# Subdivision Comments

**From:** Holly Myers, Environmental Health Supervisor

**Date:** 12/20/2016

**RE:** SP-16-00004

BROWNLEE SHORT PLAT
PART OF SECTION 36, T. 17 N., R. 19 E., W.M.
KITITAS COUNTY, WASHINGTON

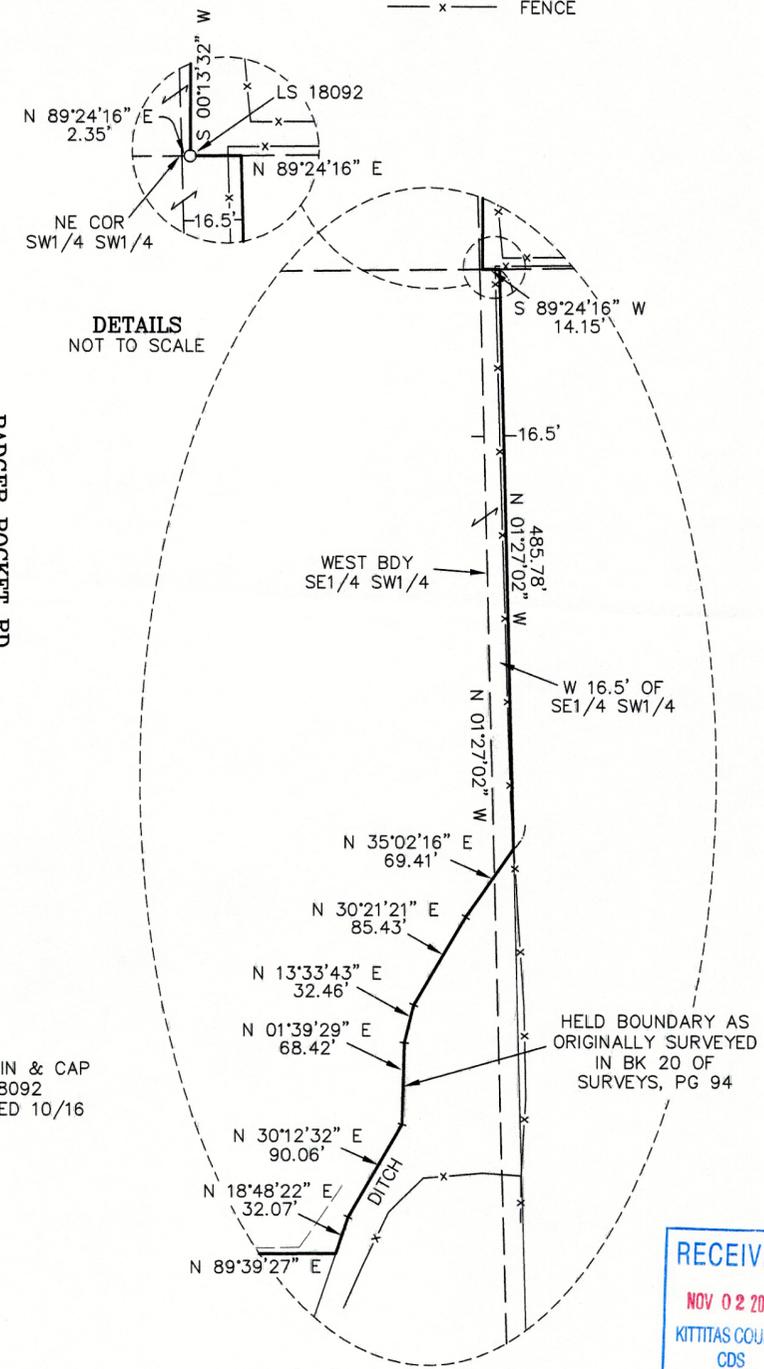
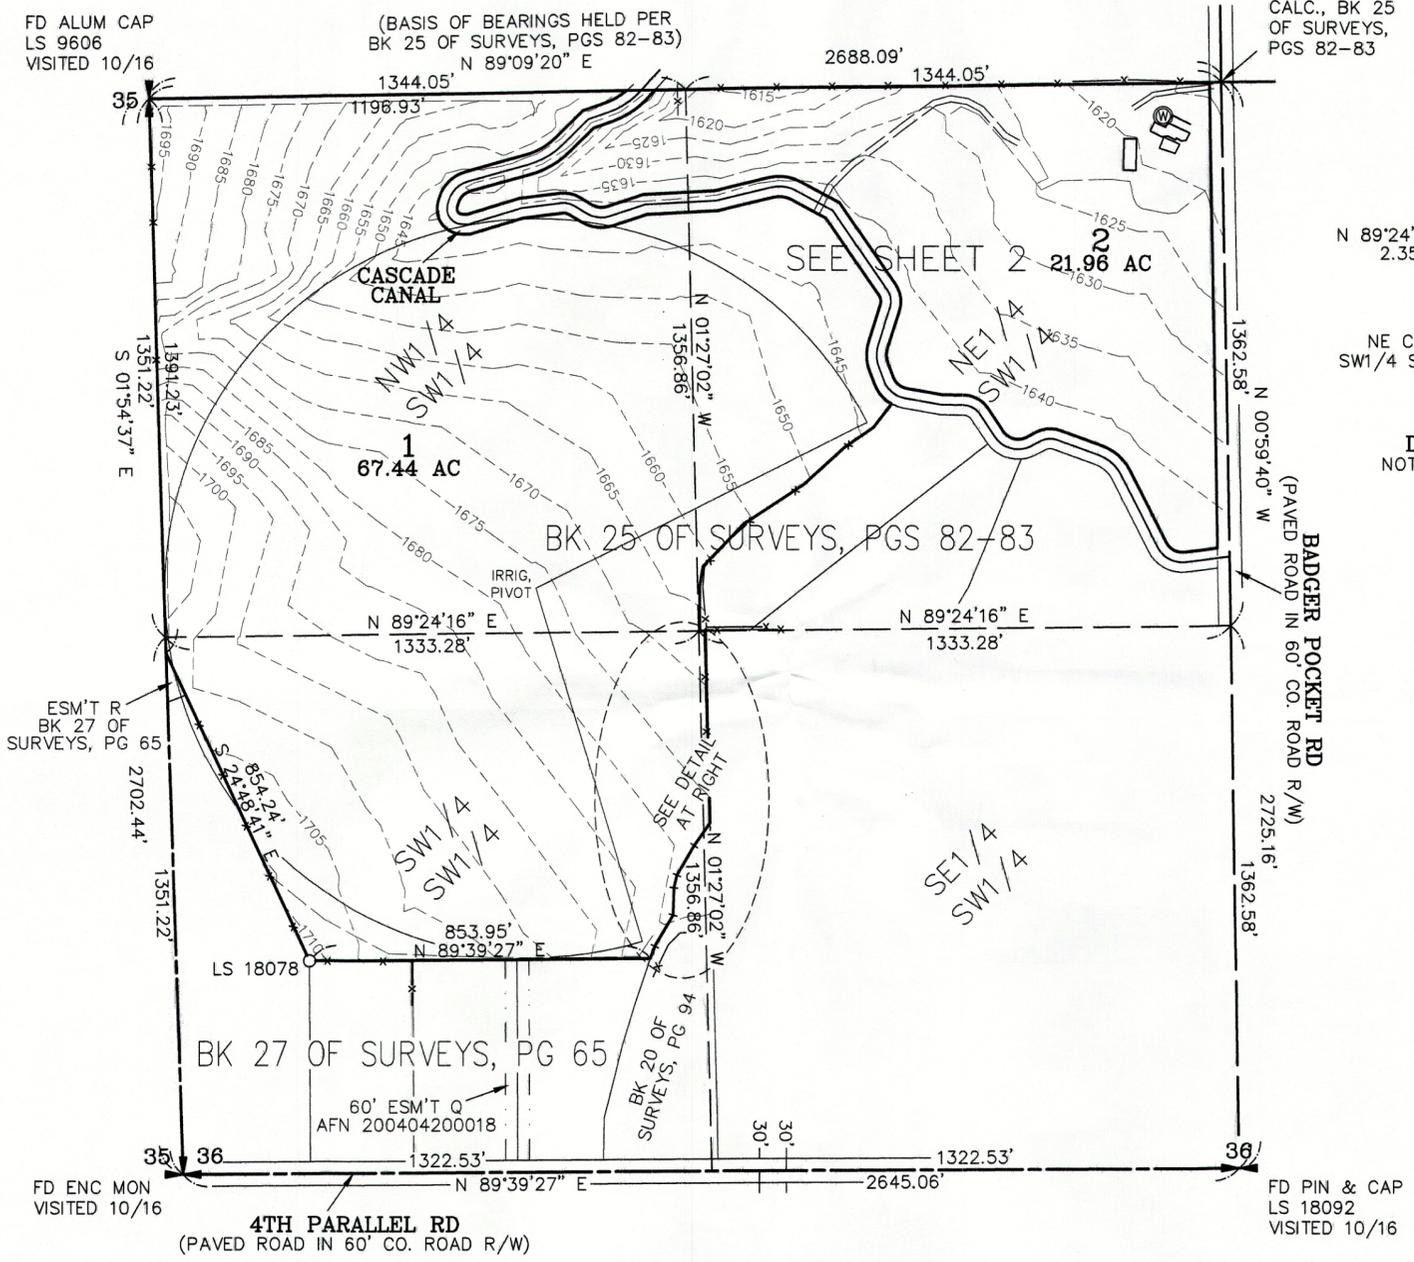
Well location. The drawings shall be marked with a "w" indicating location of the well and a broken line showing the one hundred foot radius around such. (See Condition A-3)

Per 16.20.020(9) Preliminary plat general information, A statement regarding the contemplated sewage disposal, potable water supply, and drainage improvements for the proposed subdivision are required to be placed on either sheet one or subsequent sheets of the plat.

The final plat shall contain the county health officer signature block in accordance with KCC 16.24.210. (See Condition A-6)

**A-3** The final plat drawings shall be marked with a "w" indicating location of the well and a broken line showing the one hundred foot radius around such."

**A-6** The final plat shall contain the county health officer signature block in accordance with KCC 16.24.210.

- B-1** “Metering is required for all new uses of domestic water for residential well connections and usage must be recorded in a manner consistent with Kittitas County Code Chapter 13.35.027 and Ecology regulations.”
- B-2** “The approval of this division of land provides no guarantee that use of water under the ground water exemption (RCW 90.44.050) for this plat or any portion thereof will not be subject to curtailment by the Department of Ecology or a court of law”
- B-3** A statement indicating the method of sewage disposal and potable water supply.
